Development Facilitation Team (DFT) – Review Comments

Project No: PR-2024-011129 Date: 11/20/2024 Agenda Item: #3 Zone Atlas Page: B-20

Location: 9001 Modesto Ave NE

Application For: – VA-2024-00313 – SIDWALK WAIVER

SHEET NUMBER:
A1.1

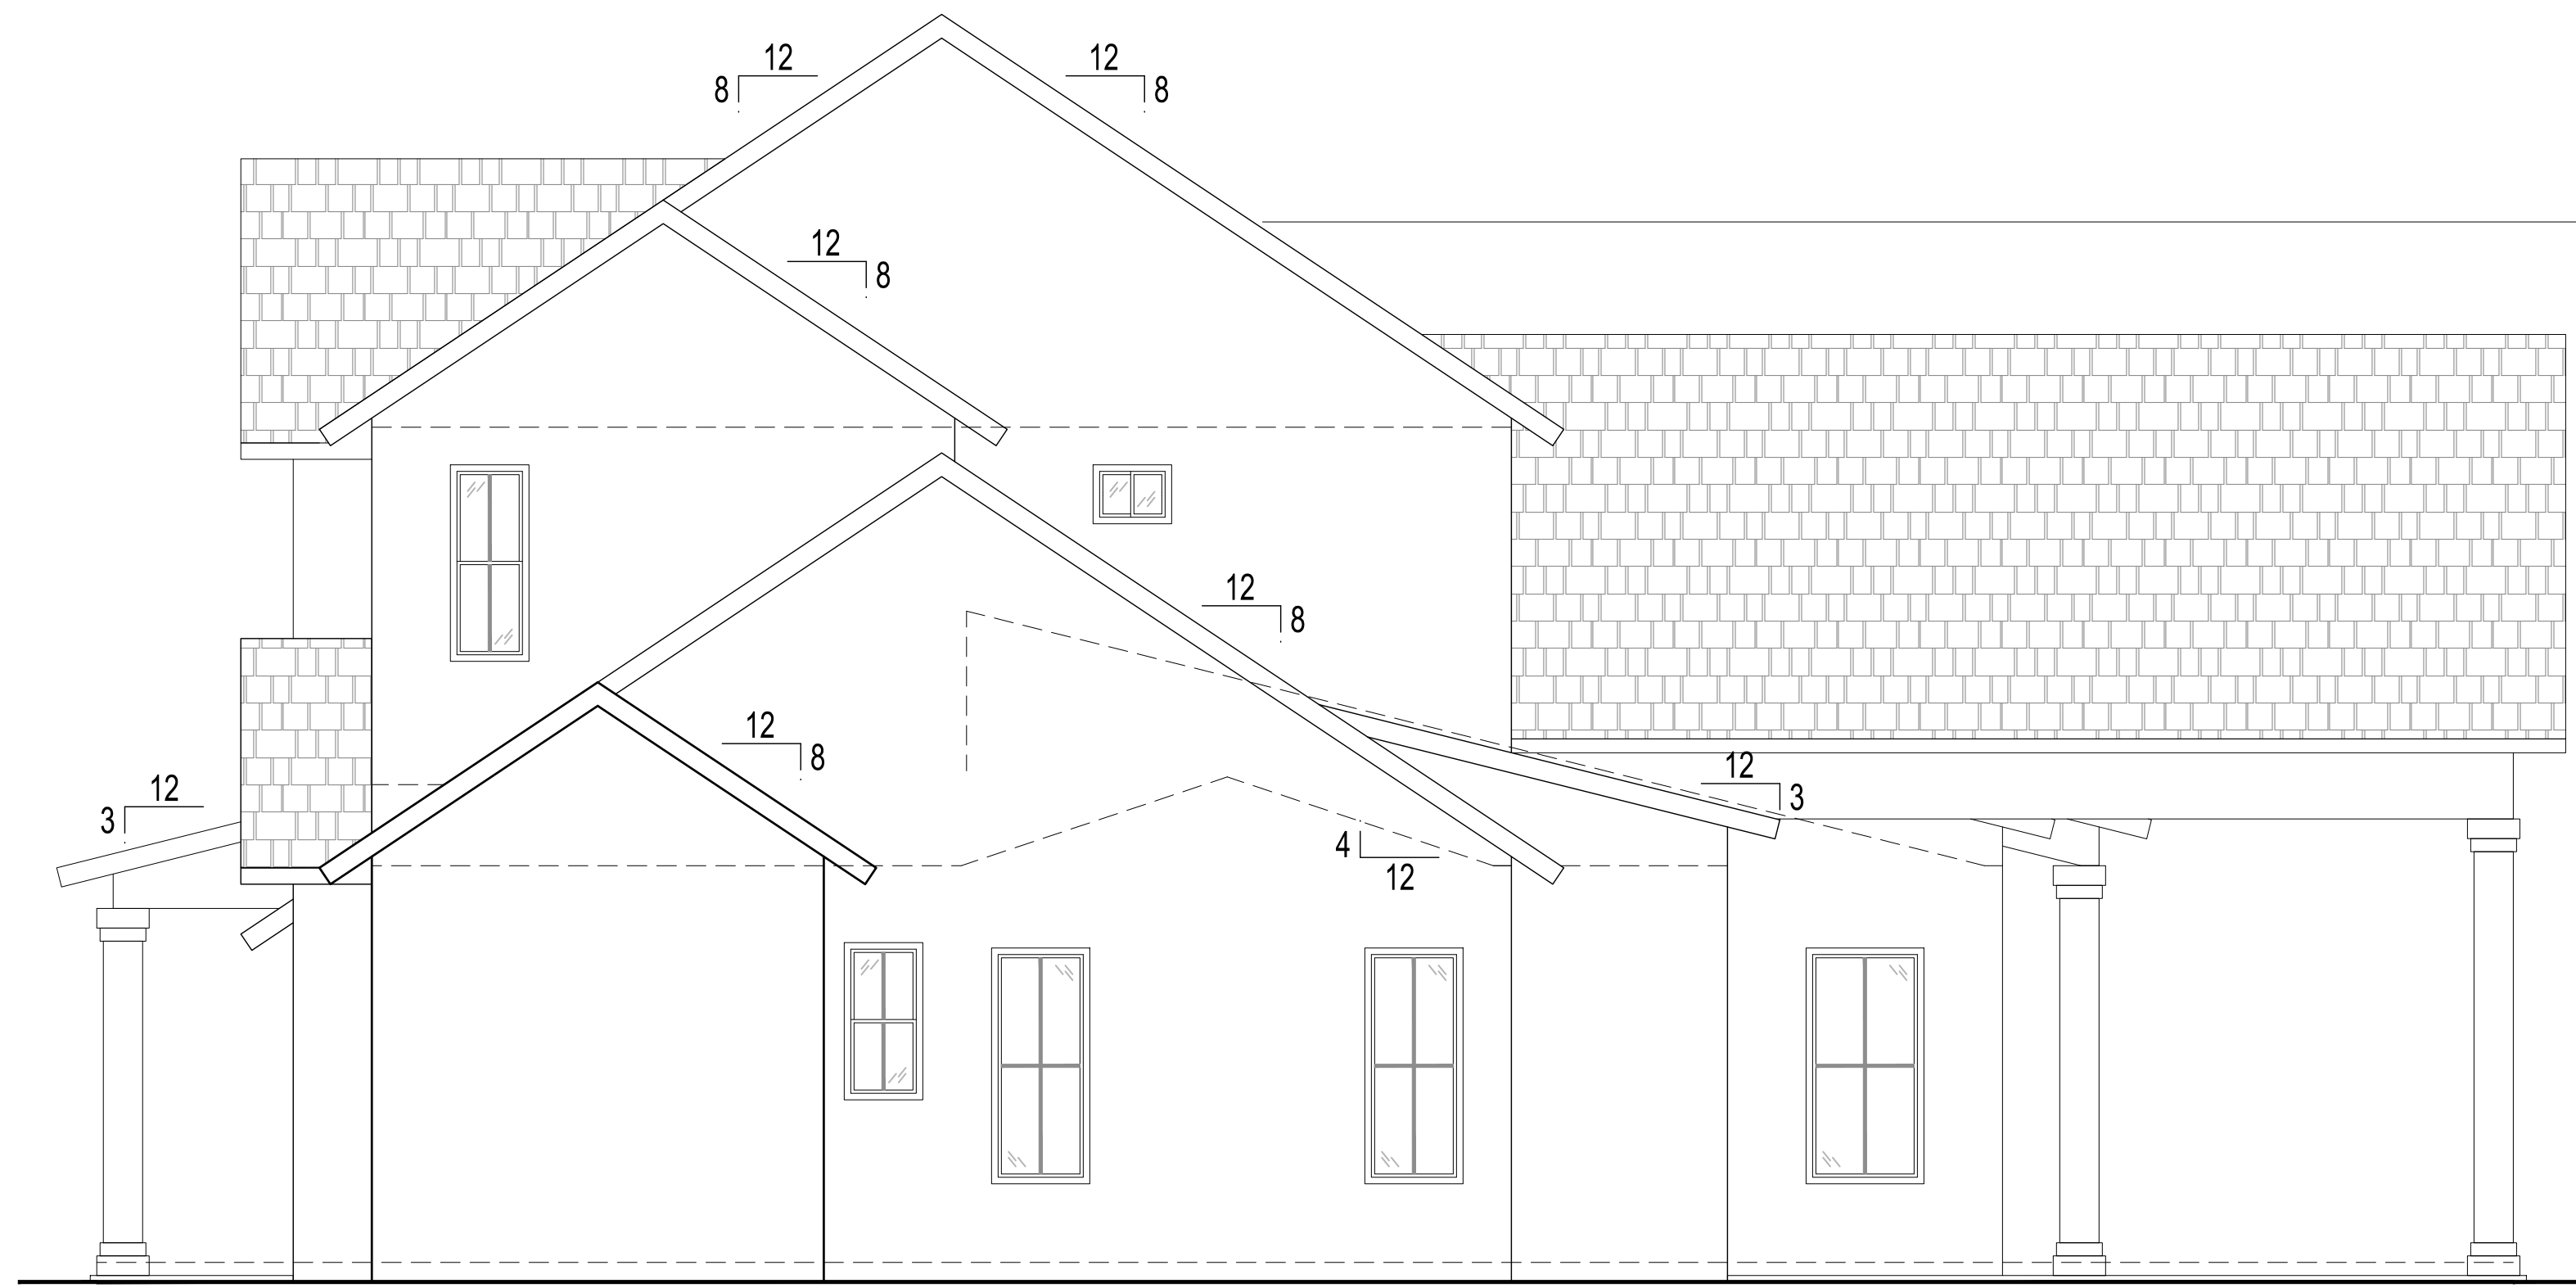
1. Transportation is not in support of the waiver of sidewalk in this area. The area is not fully developed with several lots still available to build on and there are no physical obstructions to the sidewalk. Modesto is a minor collector and requires curb, gutter, 6' sidewalk with a 5' to 6' landscape buffer.
2. Please confirm ROW limits as many of the roadways in North Albuquerque Acres area have the roadways in easement where ROW dedication would be required.

- Per 6-6(P)(2)(e) of the IDO, any Waivers granted that are associated with a Site Plan (the proposed single-family residential dwelling would require a Site Plan Administrative approval with a Building Permit(s)) shall be noted on the approved Site Plan.
